From: Kate Giddings <kate.giddings@arun.gov.uk>
Sent: 22 December 2020 12:01
To: Anita Gardner <Anita.Gardner@arun.gov.uk>
Cc: Planning.Responses <Planning.Responses@arun.gov.uk>
Subject: R/227/20/PL - 38 Oakhurst Gardens, Rustington, BN16 3AW

In relation to the above application, please may EH comment as follows:

Project	Laundry & Accommodation Oakhurst Gardens			Project No.
				010
Client	Littlehampton & Rustington Housing Society			
Date		Drawn	ES	Issue
Scale / Format	1:50 @ A1 1:100 @ A3	Checked	JT	P1
CAD Reference		Approved	SM	
Drawing Name	Laundry Elevations	Drawing No.	010-P-40-03

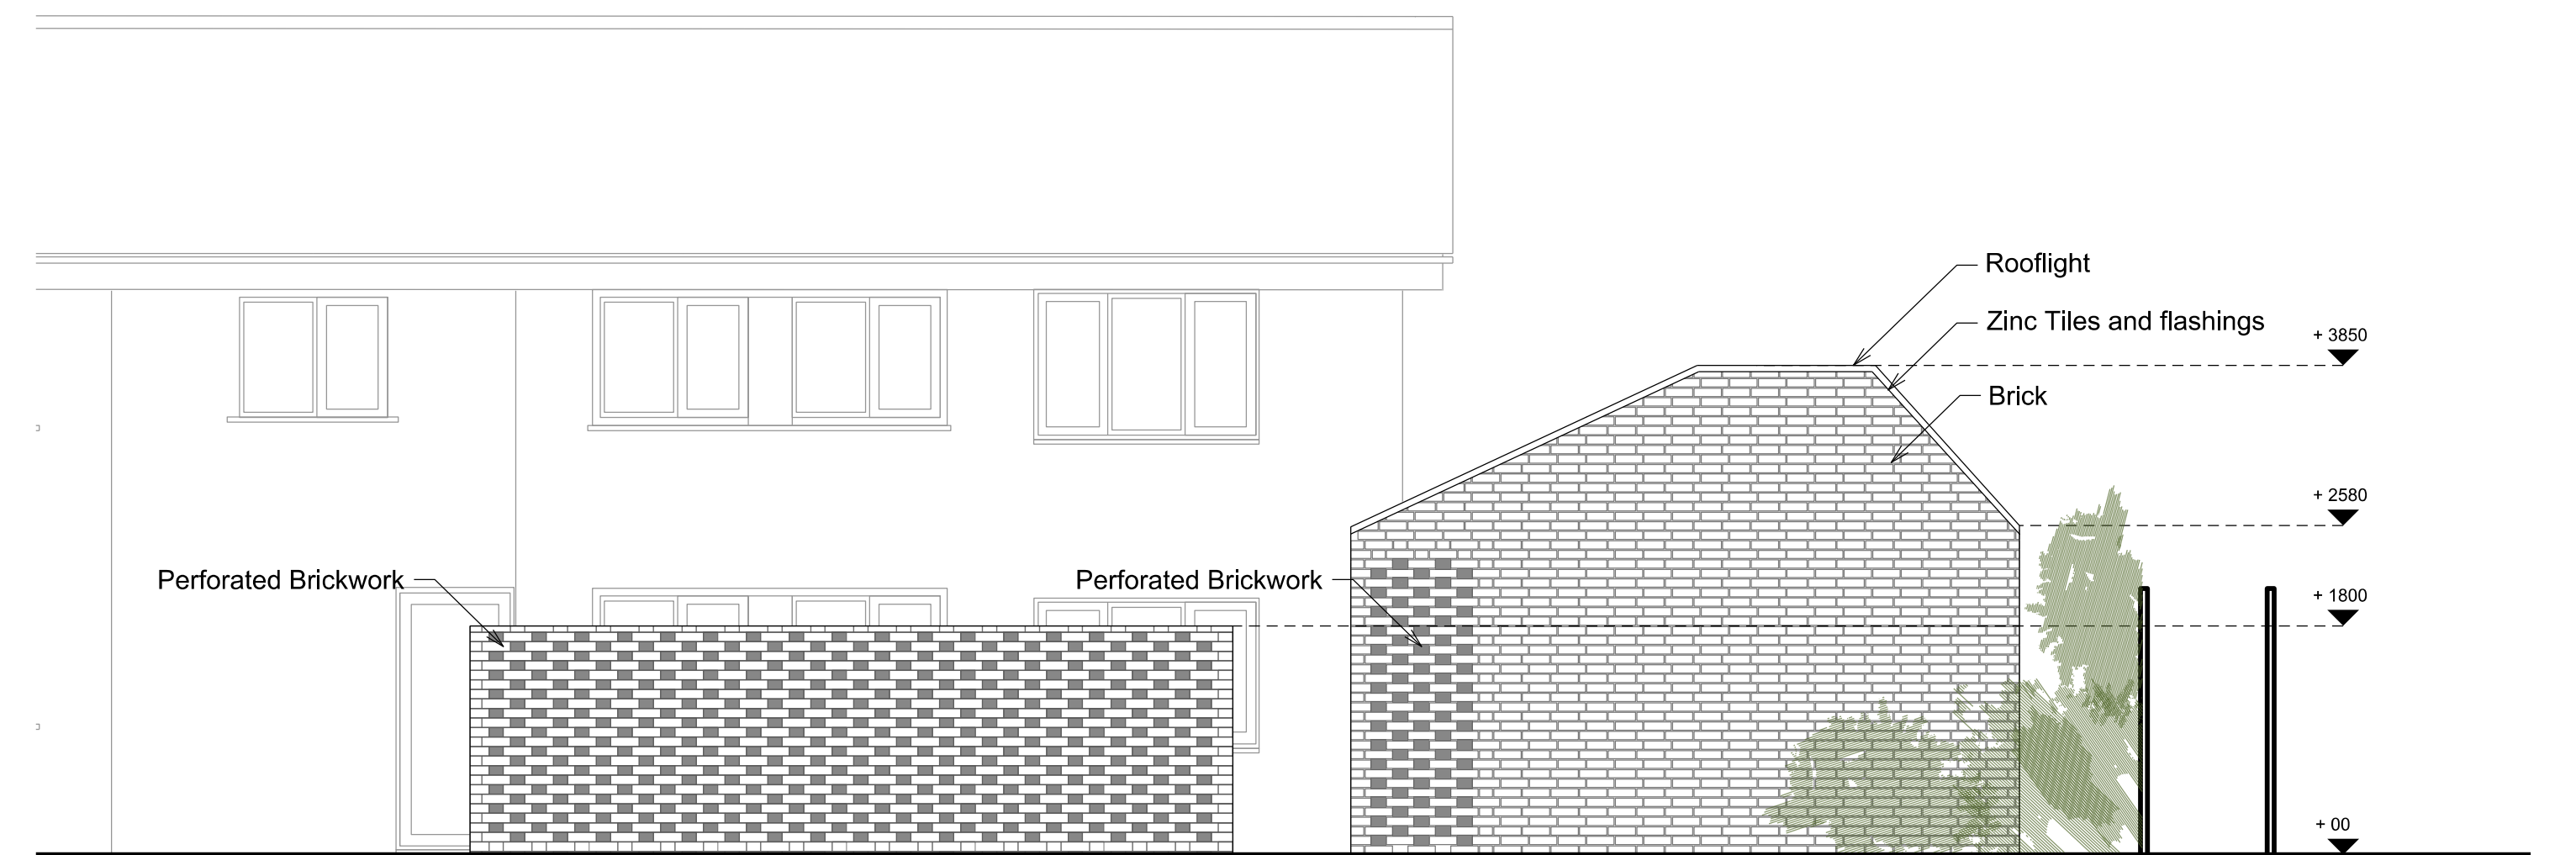
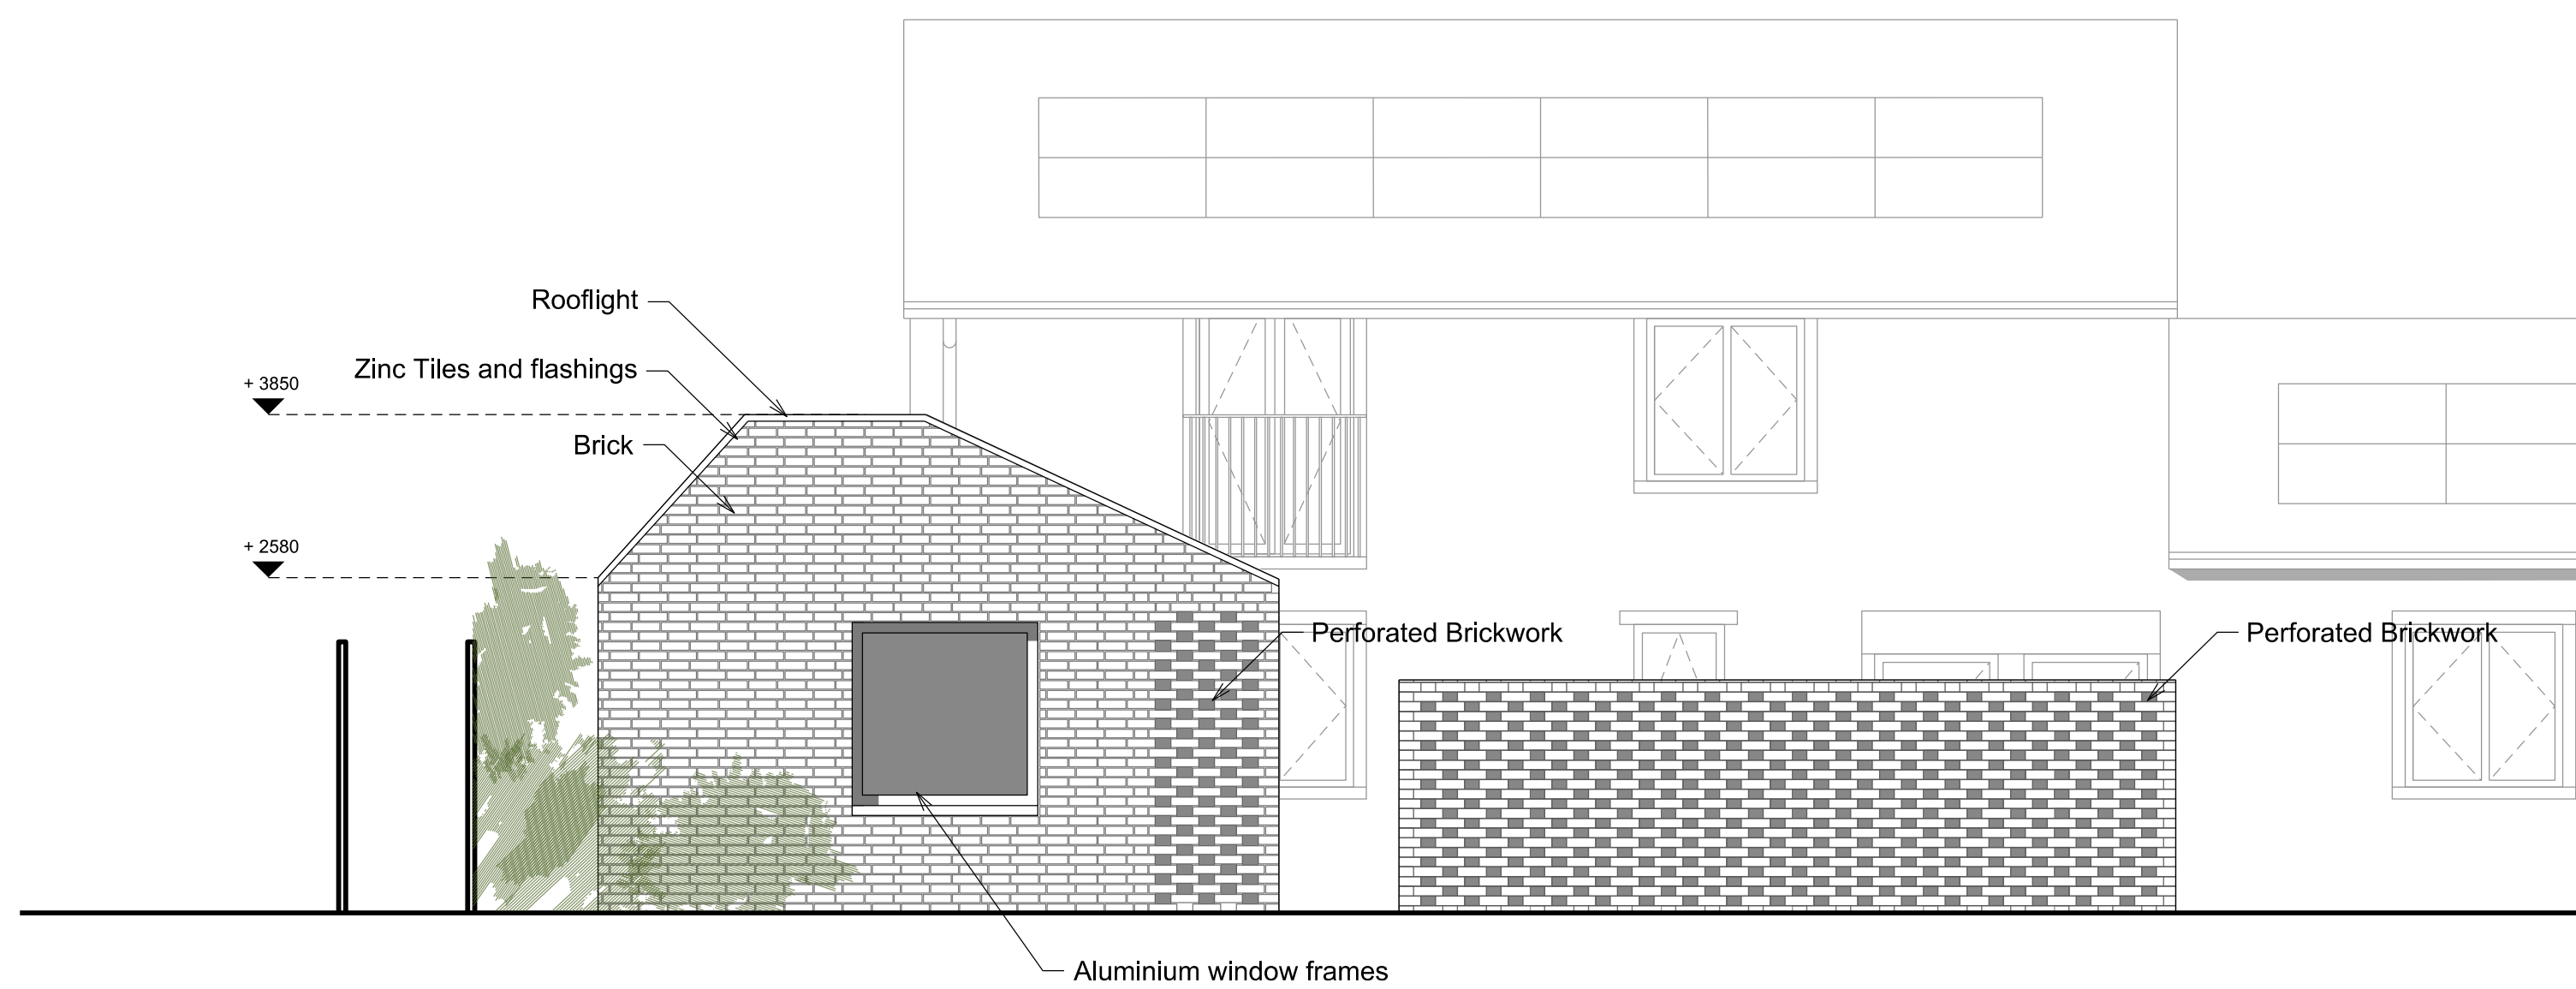
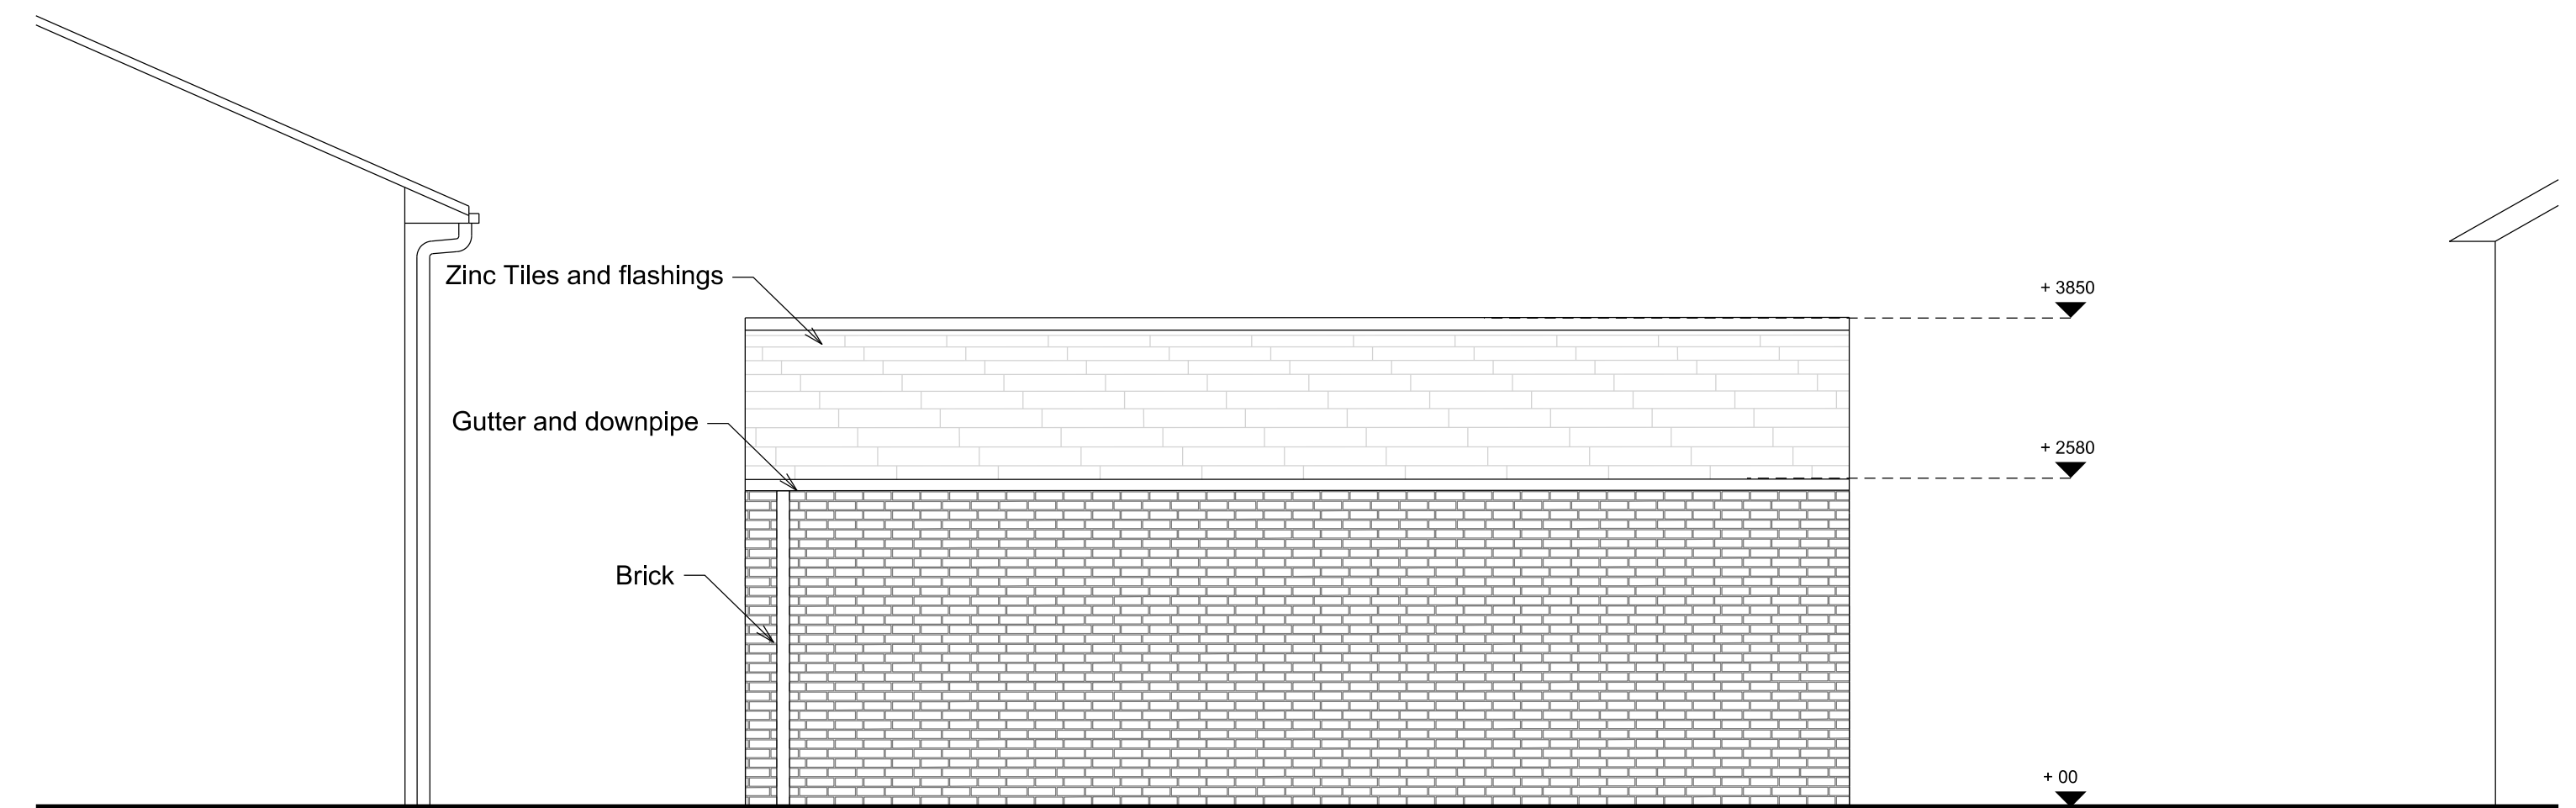
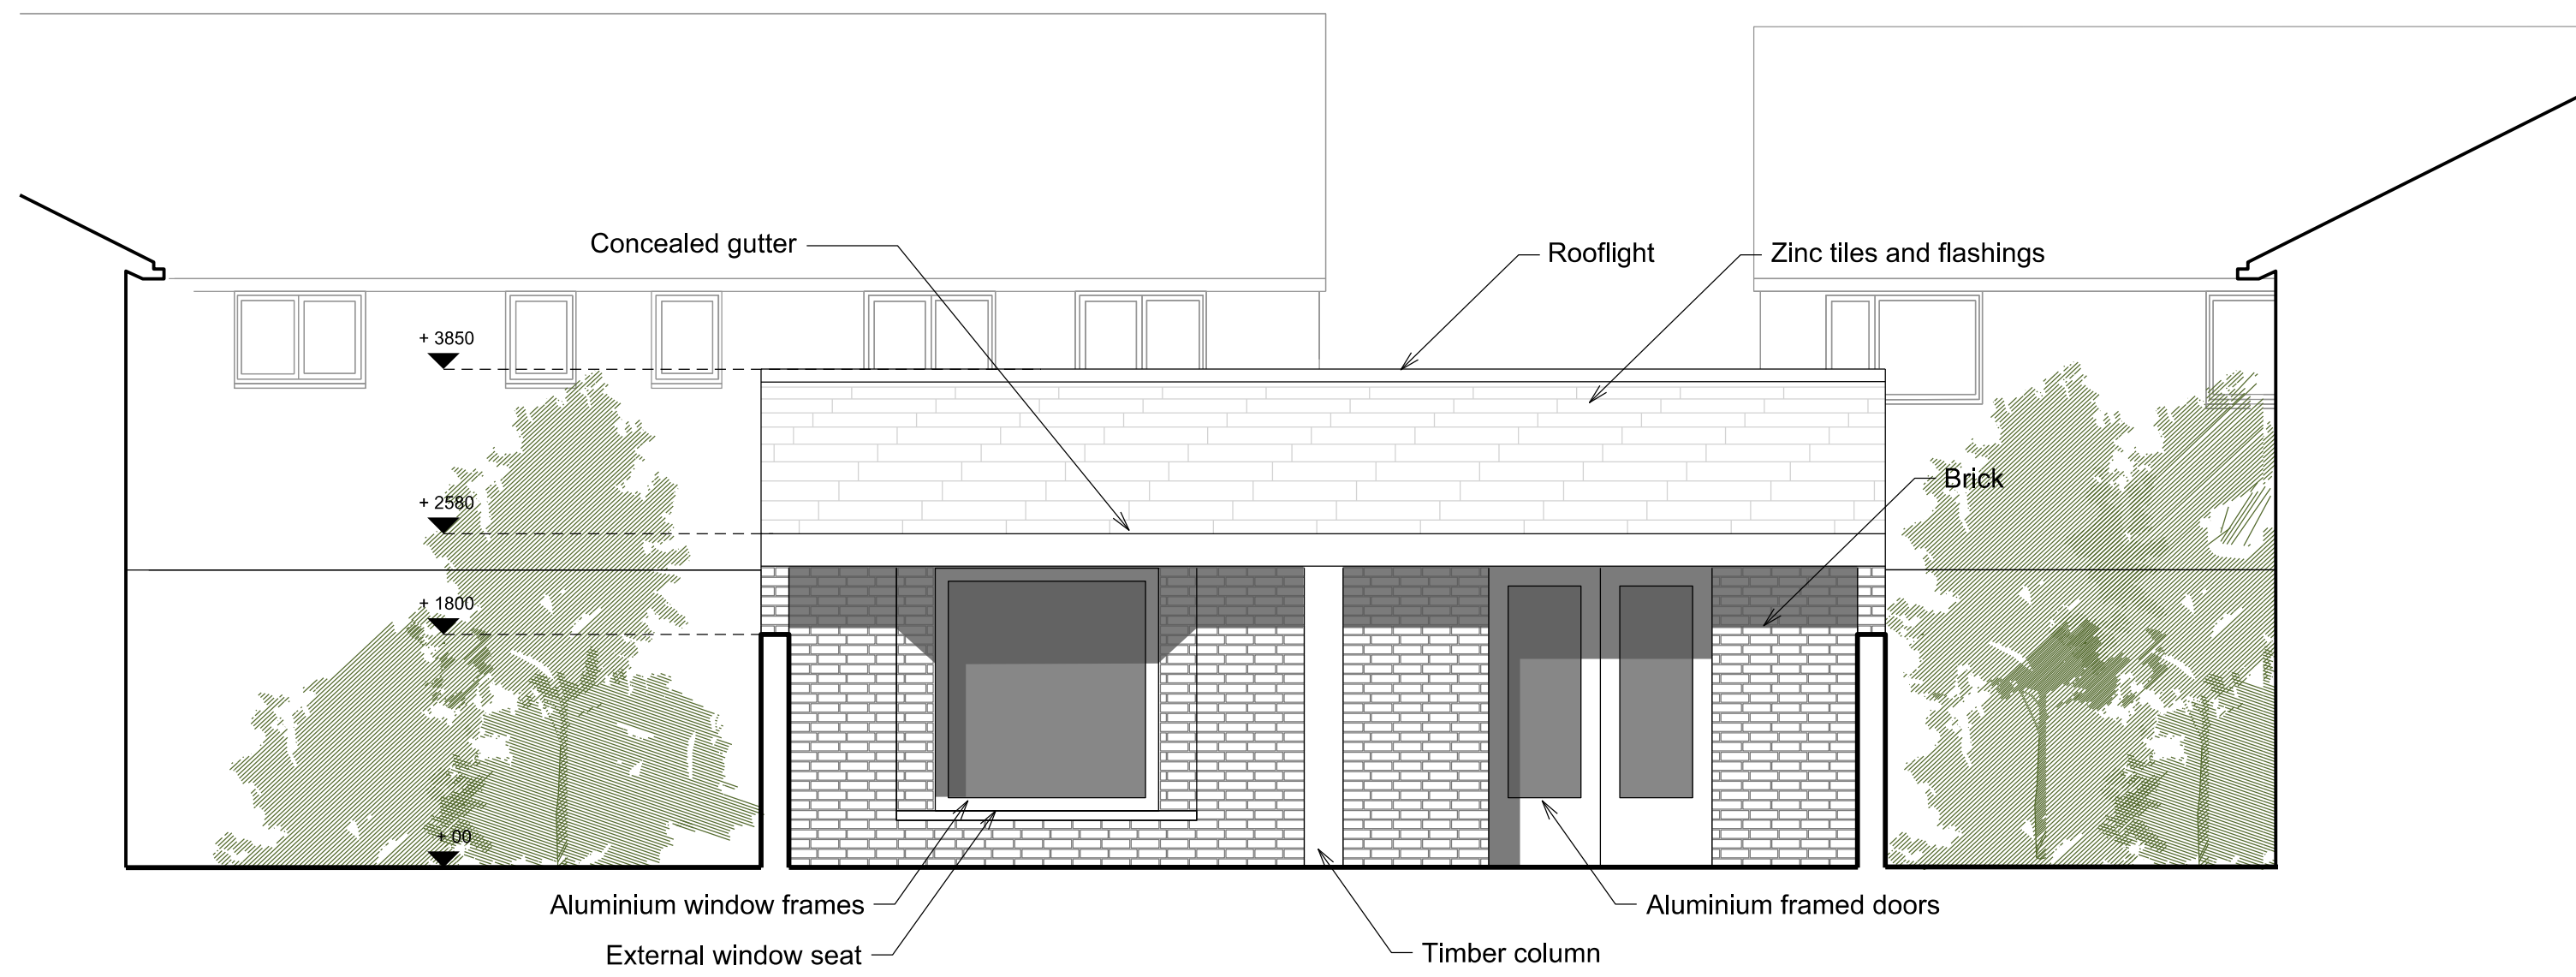
In addition, please may more detail be provided on the proposed laundry building; for example, will there be any measures in place to minimise the noise and vibration from the equipment and any associated ducting and if there are to be outlets for dryers, etc., how will the emission be managed?
